# Cottam Solar Project

## Schedule of Changes (Deadline 1)

PINS Reference: EN010133  
Document Reference: EX1/C8.1.7  
The Infrastructure Planning (Examination Procedure) Rules 2010  
Rule 8(1)(k)

### Figure 8.16.2: Landscape and Ecology Mitigation and Enhancement Plan – Cottam 1 North (Sheet 2) Revision A

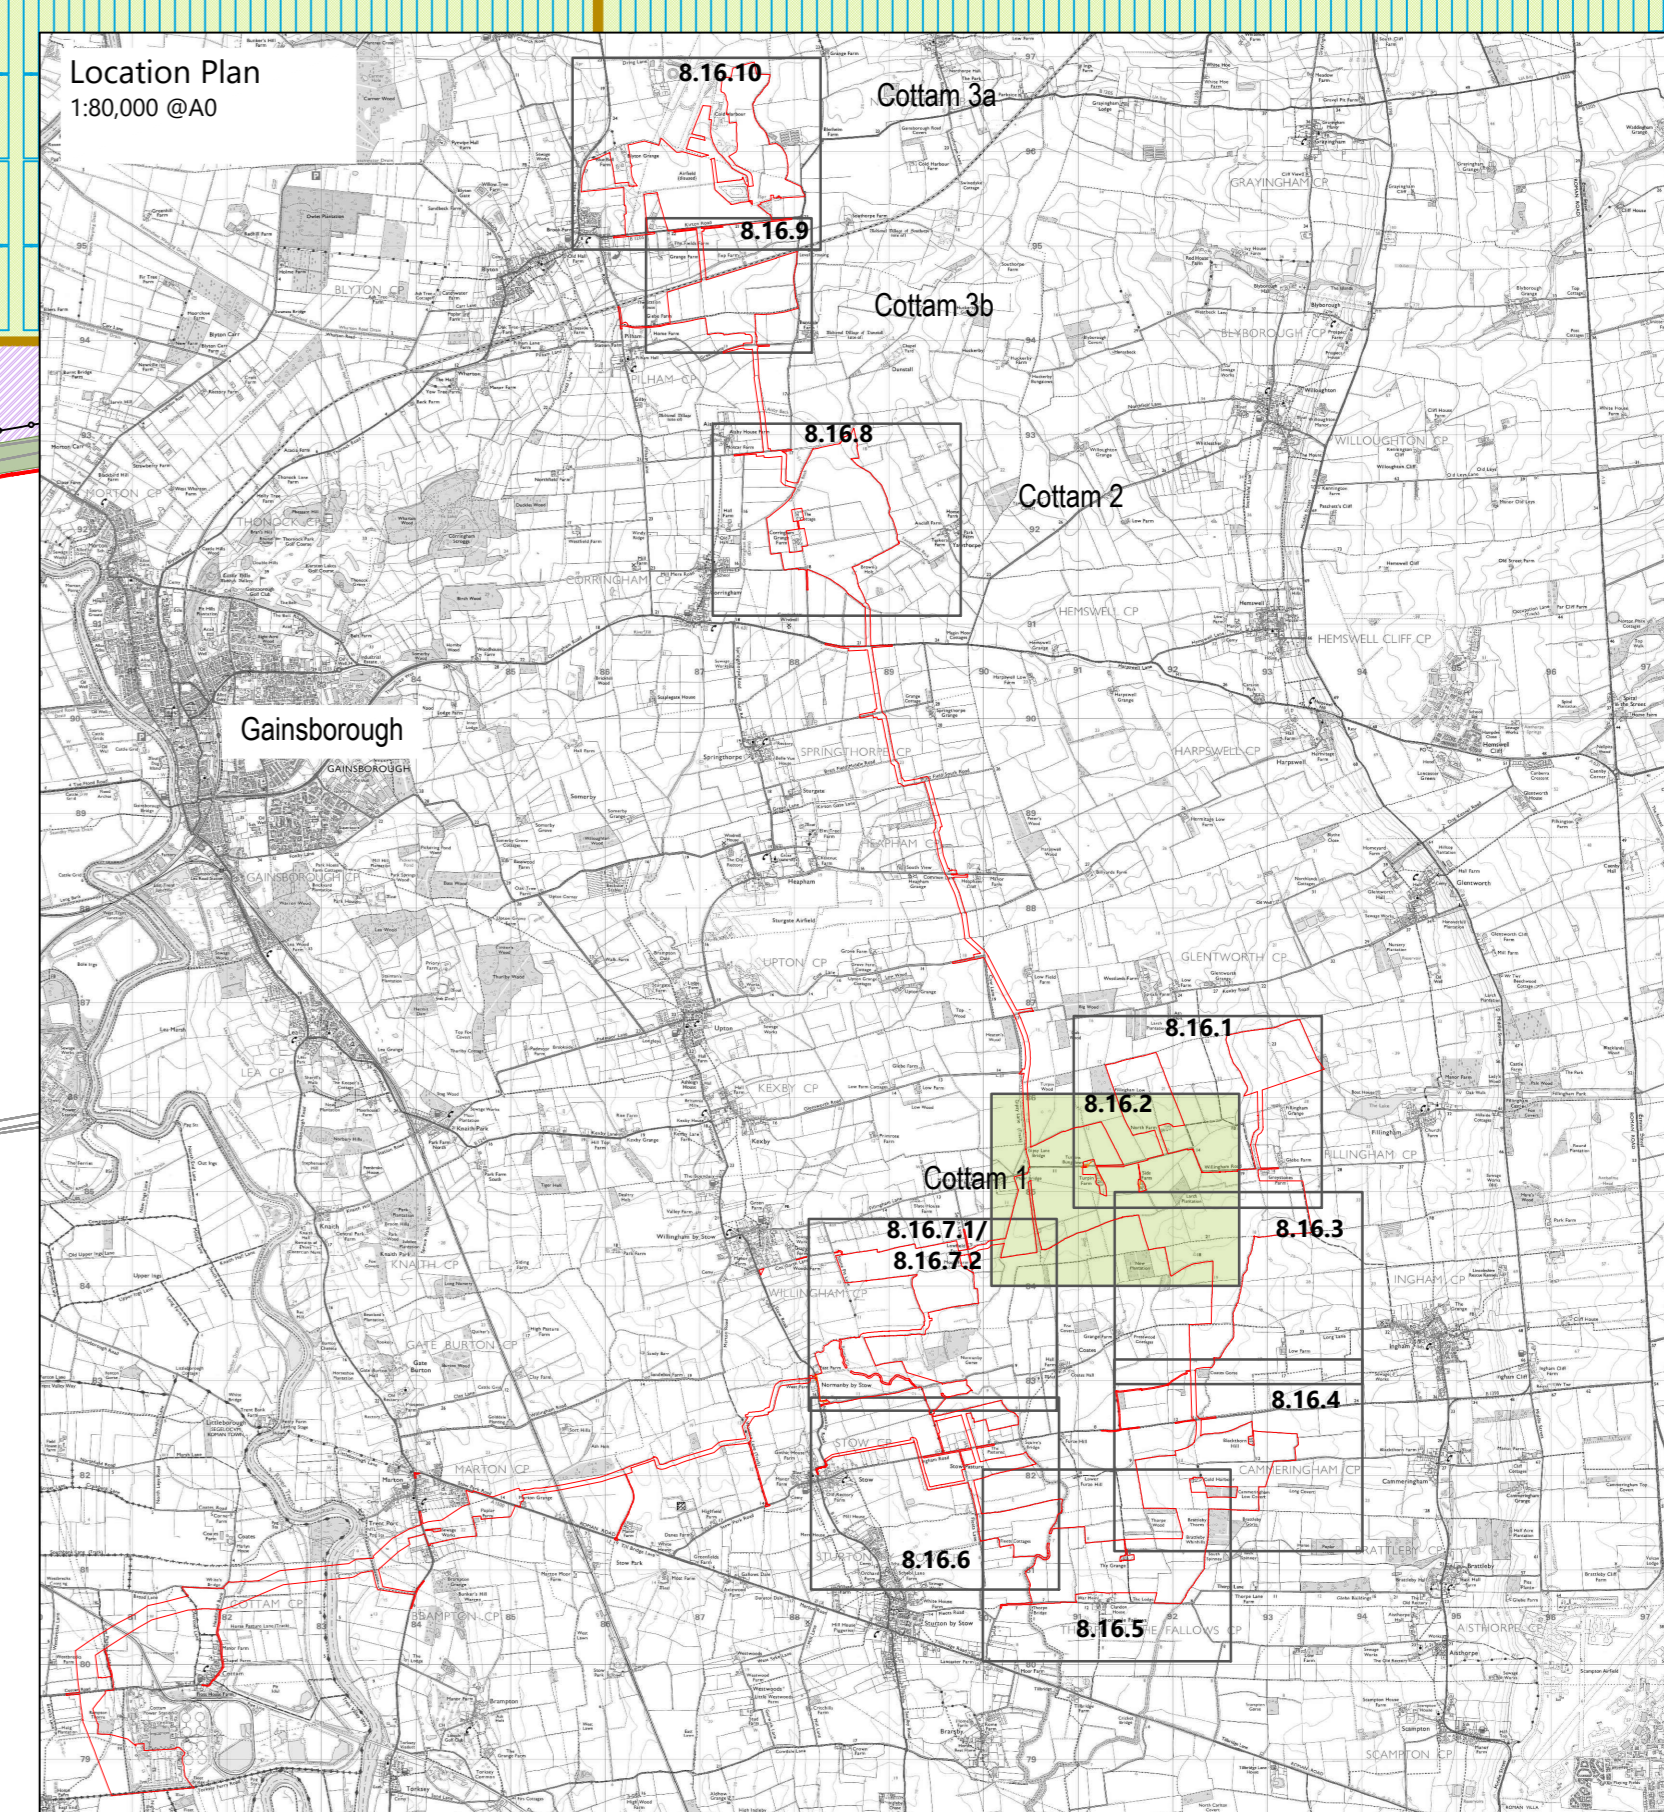
C6.4.8.16.1 to C6.4.8.16.10 Landscape and Ecology Mitigation and Enhancement Plans	[APP-305 to APP-315]	Revision A [EX1/ C6.4.8.16.1_A to EX1/ C6.4.8.16.10_A]	Deadline 1 17 October 2023	Correction of typos, to show additional hedgerows to be removed and to provide clarity of IDB Drain locations.	Minor editorial changes for clarity.
C6.5 ES Non-Technical Summary	[APP-336]	Revision A [EX1/C6.5_A]	Deadline 1 17 October 2023	Paragraphs 6.3.14 to 6.3.16, and 6.3.20 to 6.3.21, updated clarifying as to which part of the Site, and which assessment period the effects relate to.	To provide clarity and consistency and minor editorial changes.

Figure number Date
11 **06/10/2022**

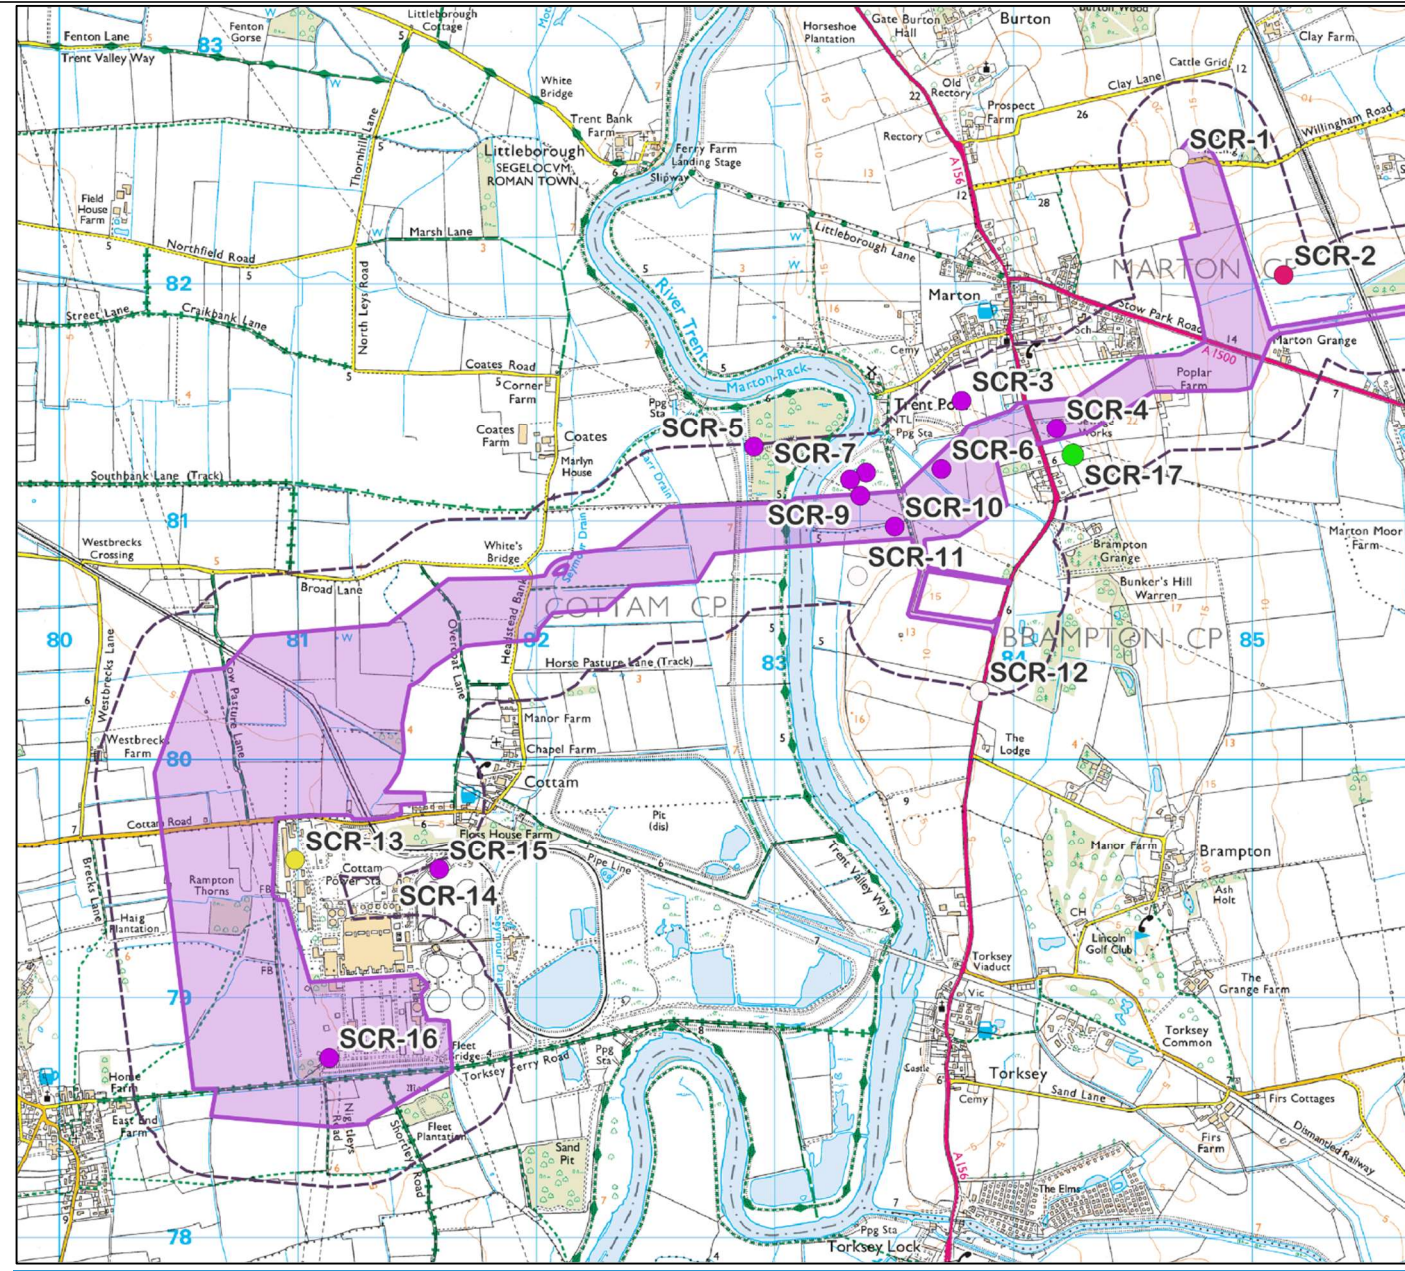
C6.3.9.7 Great Crested Newts Survey Report	[APP-084]	Revision A [EX1/ C6.3.9.7_A]	Deadline 1 17 October 2023	Paragraphs 2.2.11, 4.1.6 and Figure 11, added; Paragraph 2.2.22 deleted and Paragraphs 3.2.6, 4.1.2, 4.1.5, 4.1.7, 4.2.4 and Tables 7, 12 updated to include 2023 Great Crested Newts Survey.	To provide information on the likely presence or likely absence of Great Crested Newts for 6 additional ponds along the cable corridors where access had not been previously arranged and of a further three ponds which were previously found to be dry.
C6.3.14.2 Construction Traffic Management Plan	[APP-135]	Revision A [EX1/ C6.3.14.2_A]	Deadline 1 17 October 2023	Construction Traffic Management Plan updated to take equestrians and reinstatement of private roads into account.	ExA Request ISH1 and to address the British Horse Society's Relevant Representation [RR-023].
